EXHIBITION OF ENVIRONMENTAL ASSESMENT FOR THE AUSTRALIAN HEARING HUB – MACQUARIE UNIVERSITY (MP10_0032)

ENVIRONMENTAL ASSESSMENT AUSTRALIAN HEARING HUB (MP10_0032) DETAILED COMMENTS

BASEMENT 1

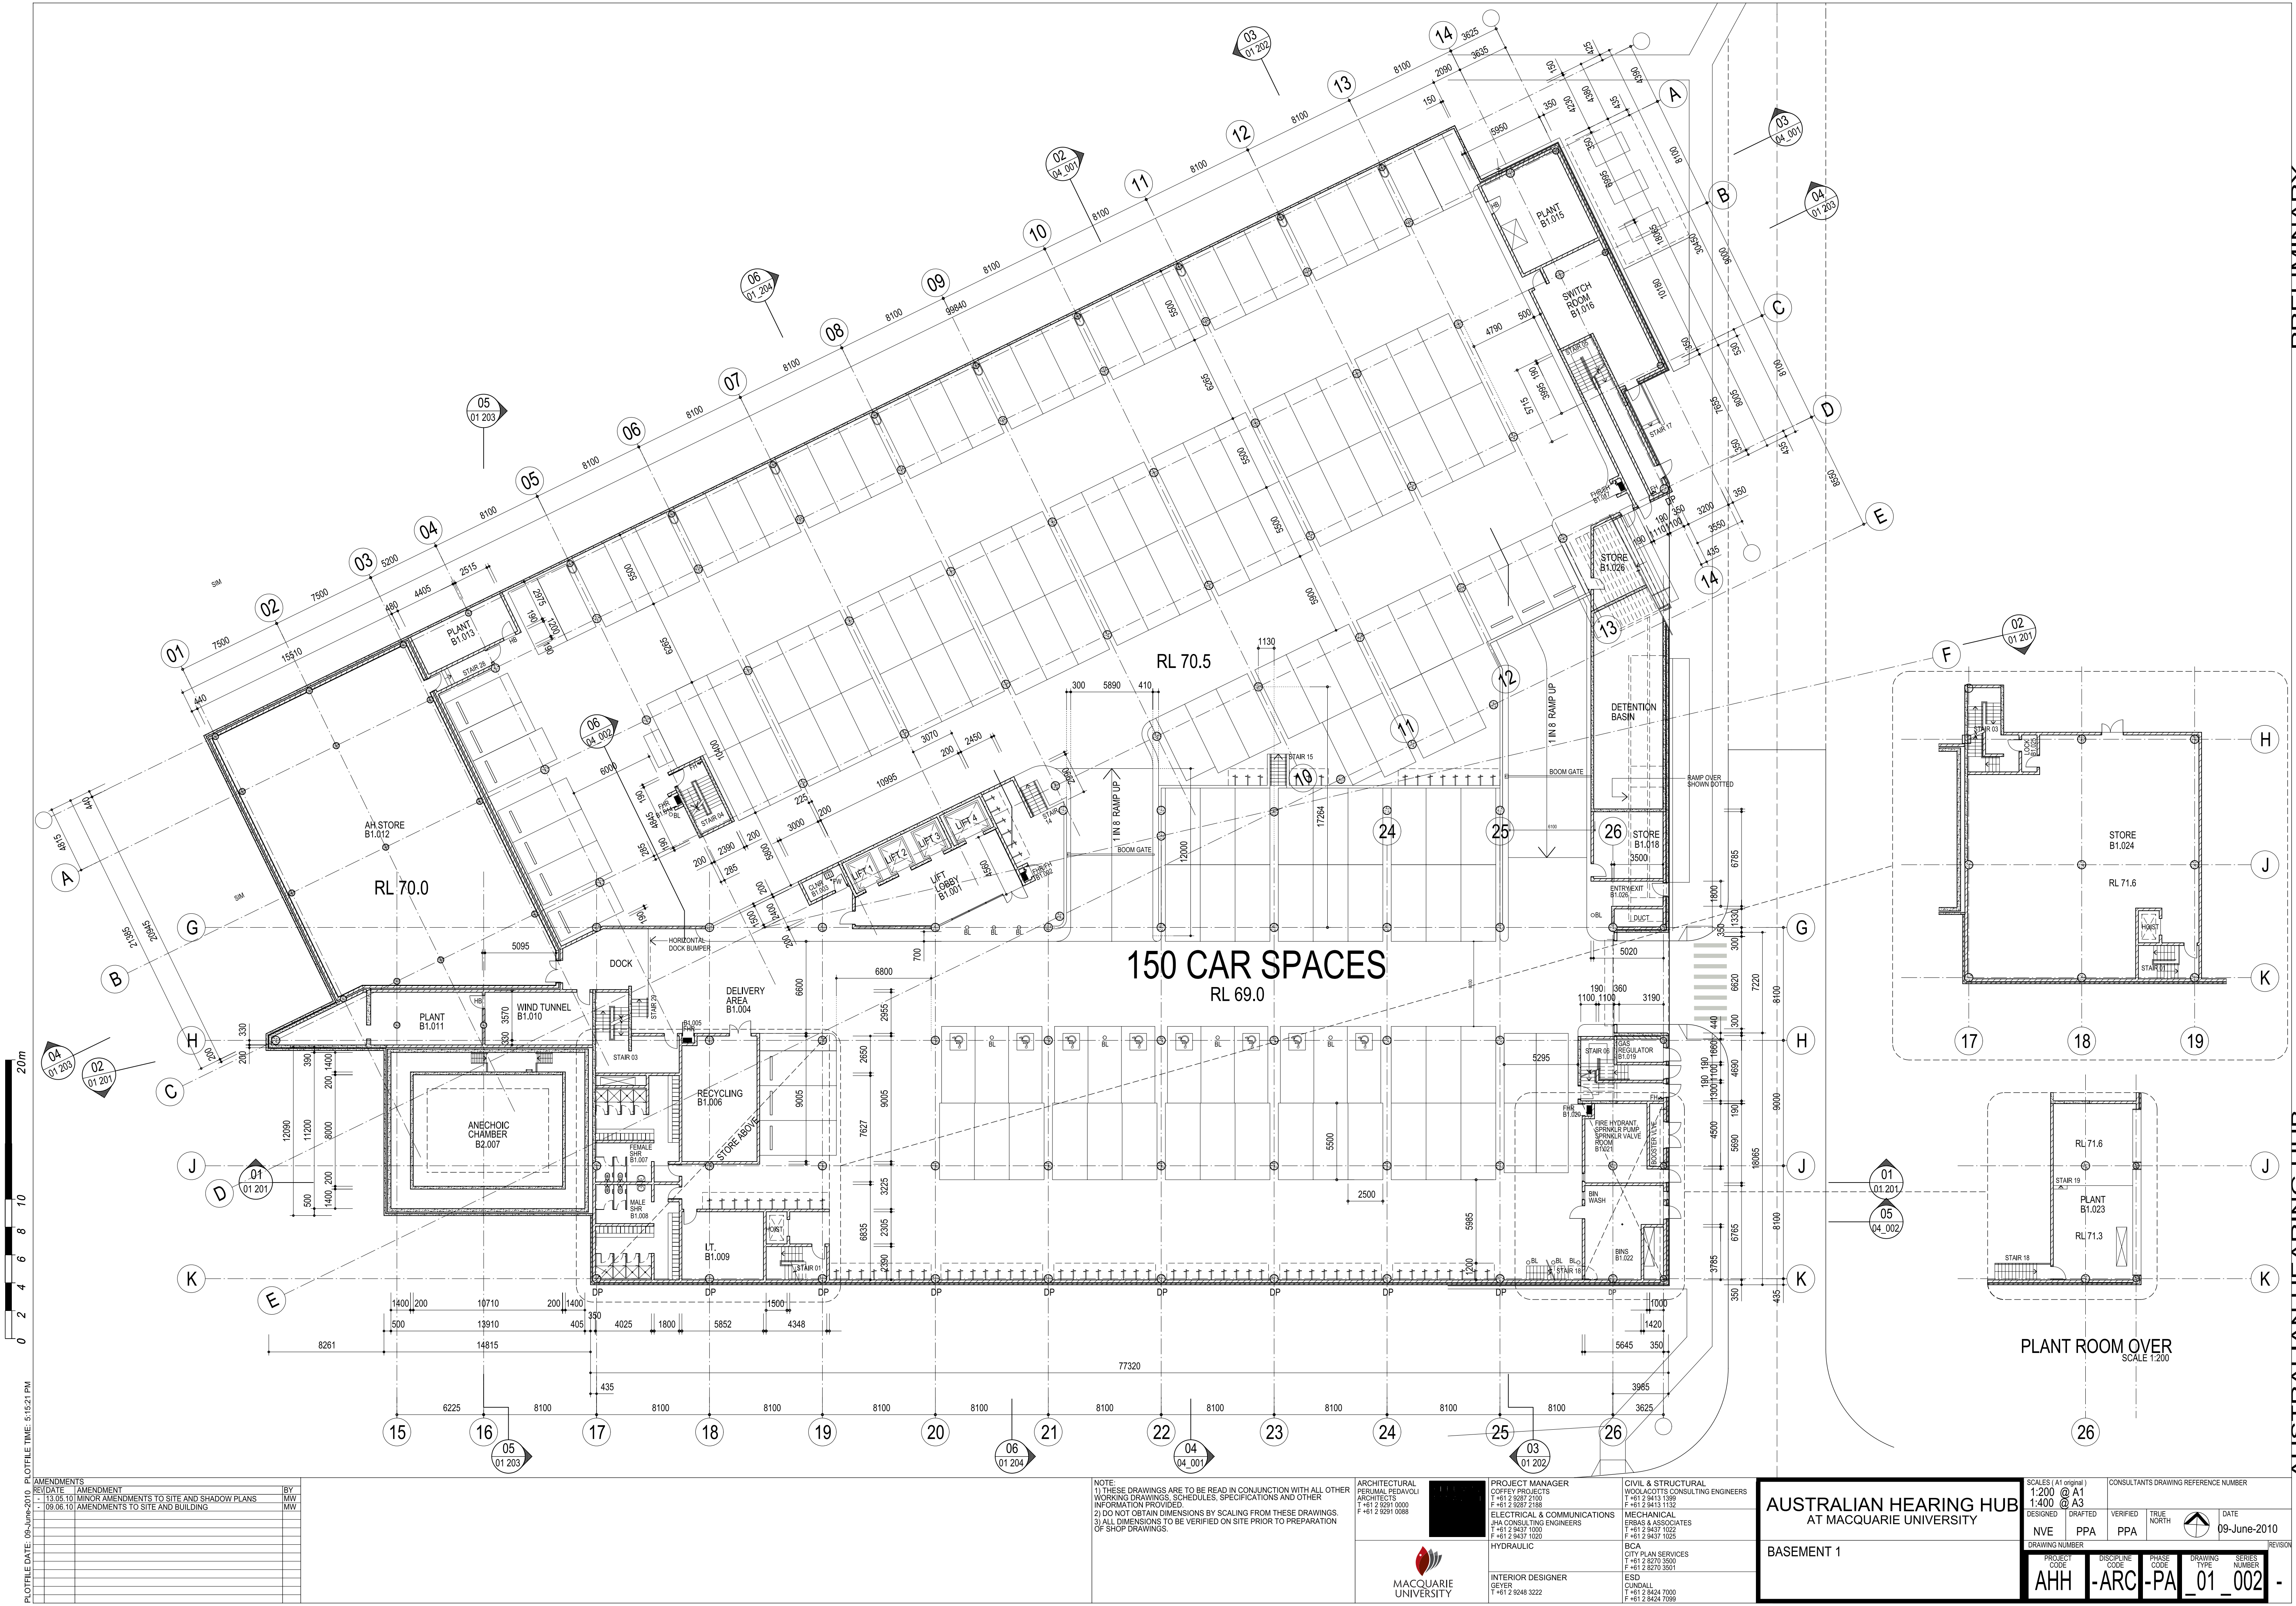
TNSW supports a minimalist approach to car parking in locations well serviced by public transport. Given the accessibility of the site to both rail and bus transport as well as walking and cycling facilities, TNSW recommends the car parking spaces be reduced to a maximum of 290 spaces in accordance with the maximum rates outlined in the approved Macquarie University Concept Plan (MUCP) which recommends 1 space per 80m² of Gross Floor Area across precincts E and F.

TNSW notes the proponent's consideration of a number of sustainable transport options including car sharing, car pooling, Workplace Travel Plans (WTP) and discounted annual public transport tickets. However, TNSW is concerned that only a WTP is included in the draft statement of commitments. TNSW requests that the following Travel Demand Management measures also be included in the final Statement of commitments:

- Provision of car pooling and car share spaces in priority locations; and
- Preparation of a Travel Access Guide (TAG) for visitors to the site. Information on how to prepare a TAG is available at www.rta.nsw.gov.au.

GROUND FLOOR PLAN

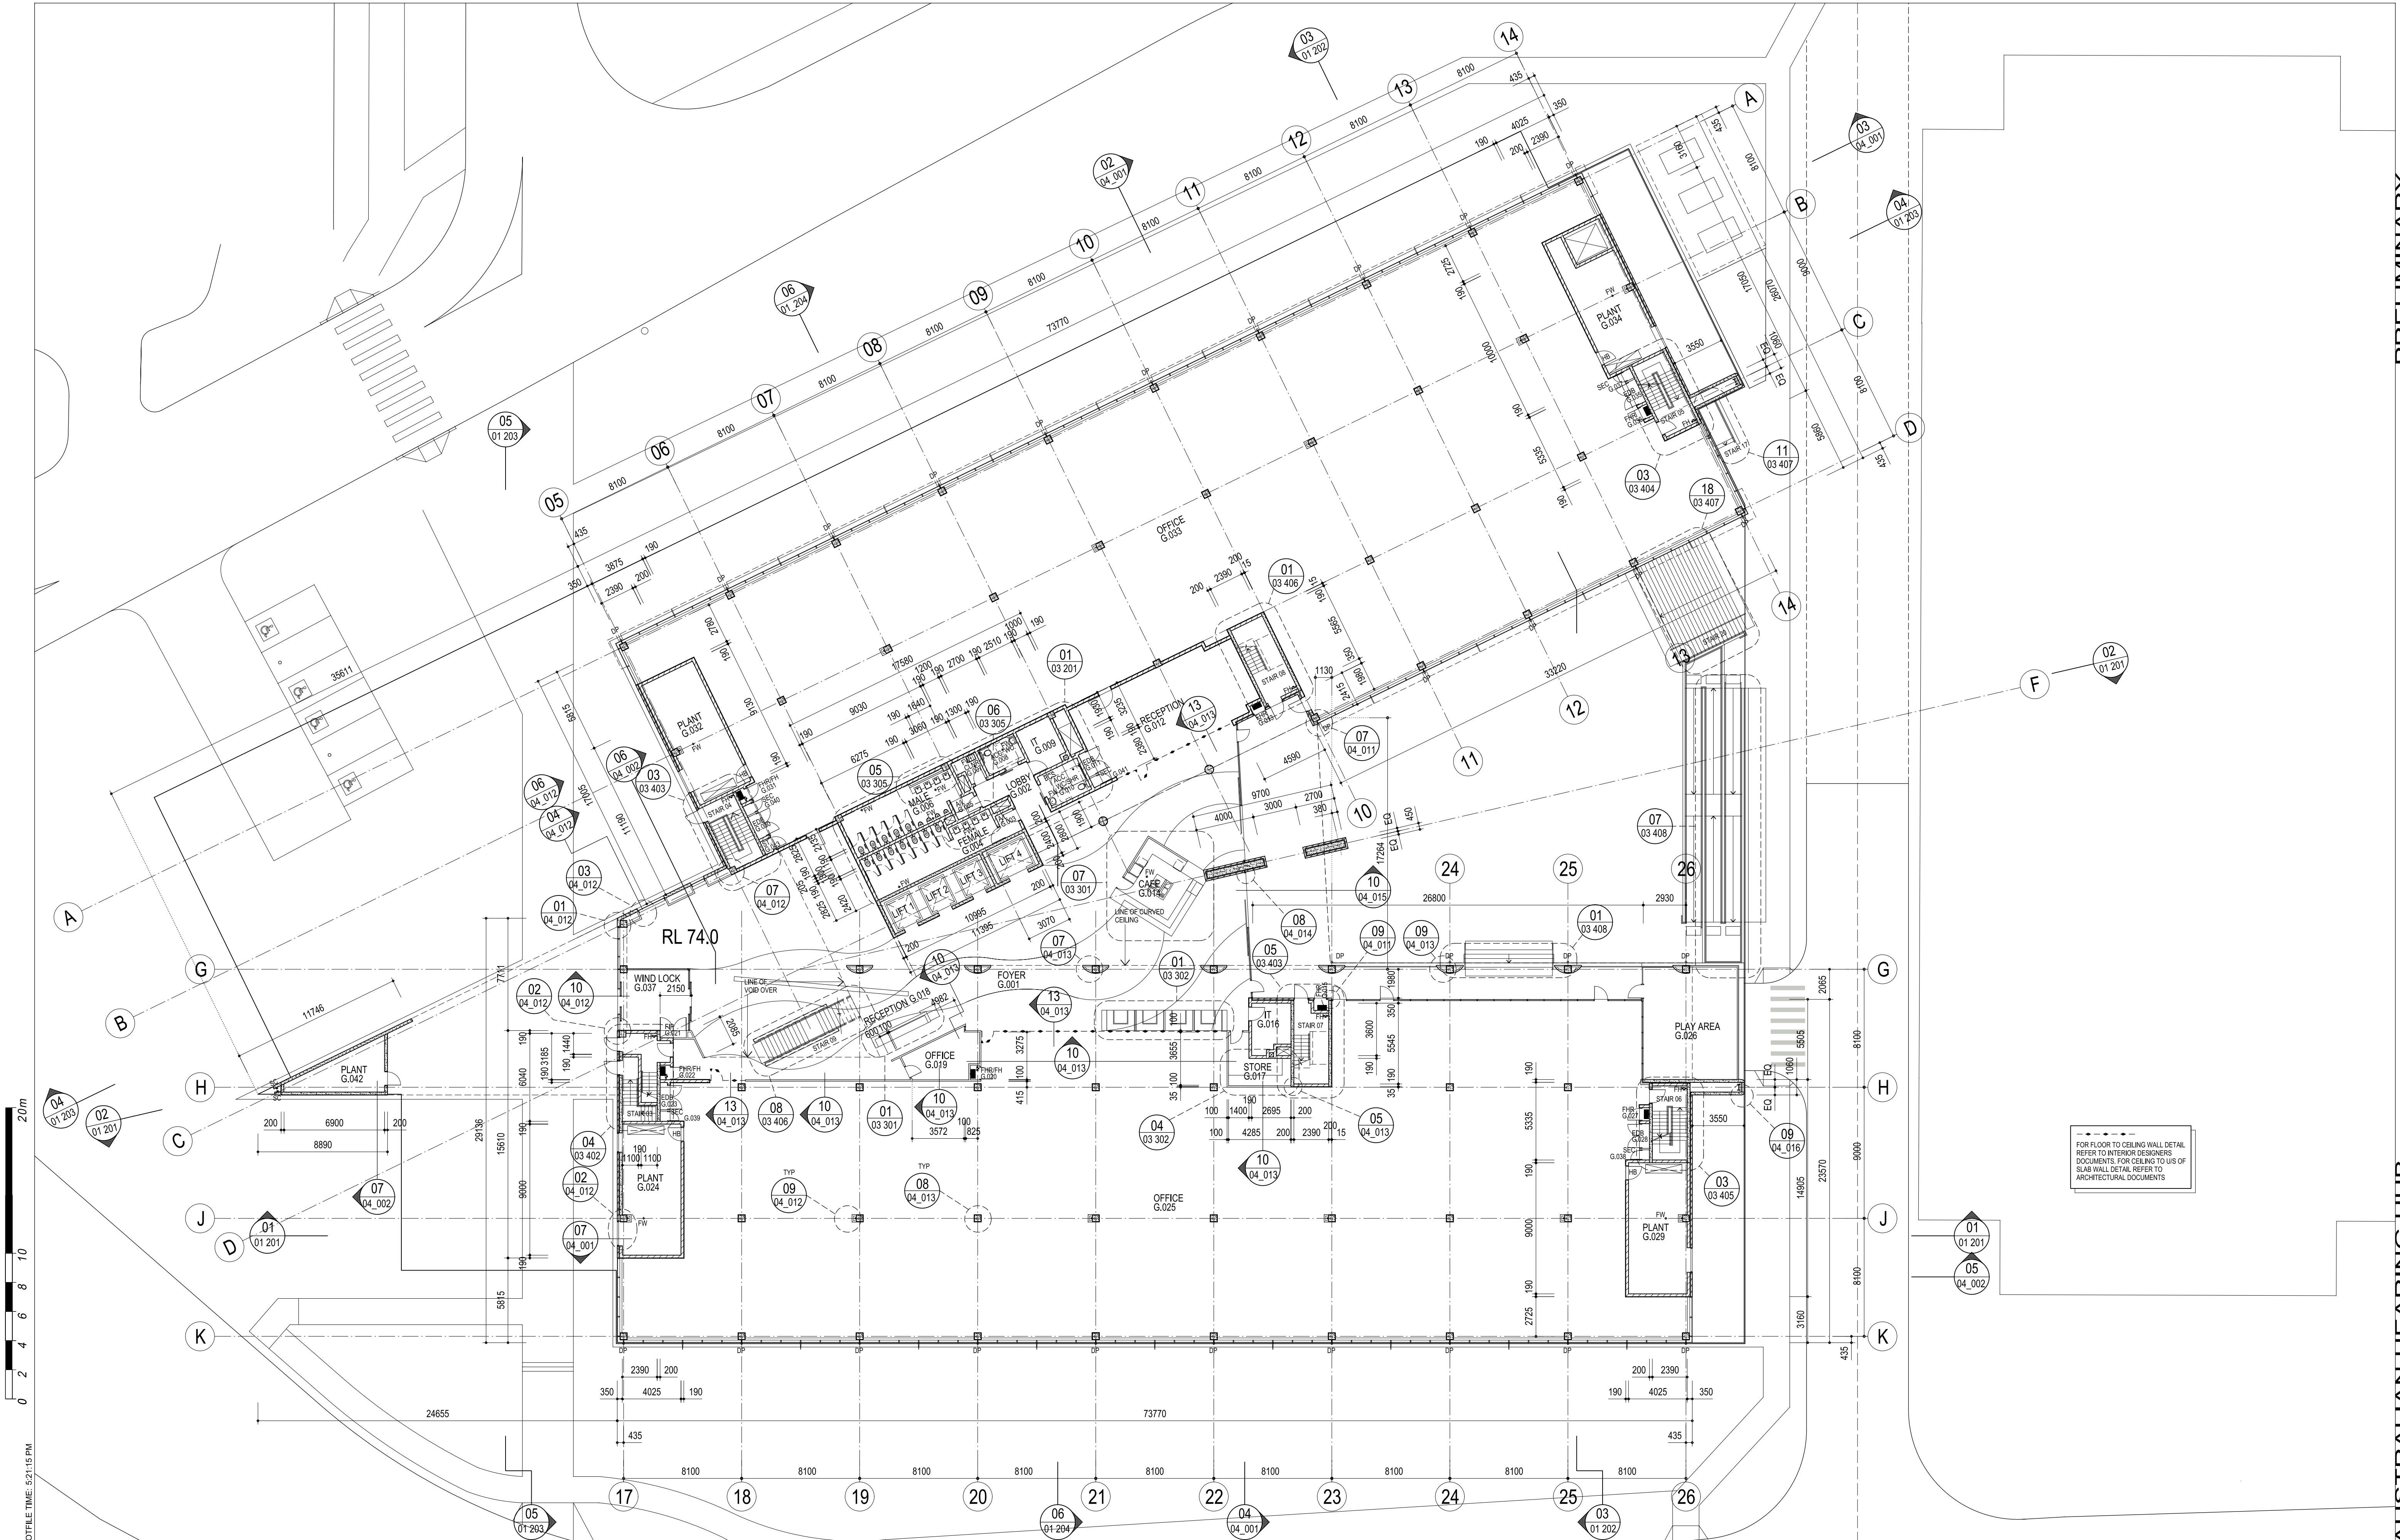
TNSW notes the provision of 159 bicycle spaces as well as end of trip facilities for cyclists and pedestrians. TNSW requests that bicycle parking for staff should be prioritised in convenient locations that are well lit, sheltered and secure. Provision should also be made for visitor bicycle parking at grade and located close to major entrances in well lit and secure locations. The Department's Planning Guidelines for Walking and Cycling (2004) and the NSW Bike Plan (2010) provide relevant context and specifications.
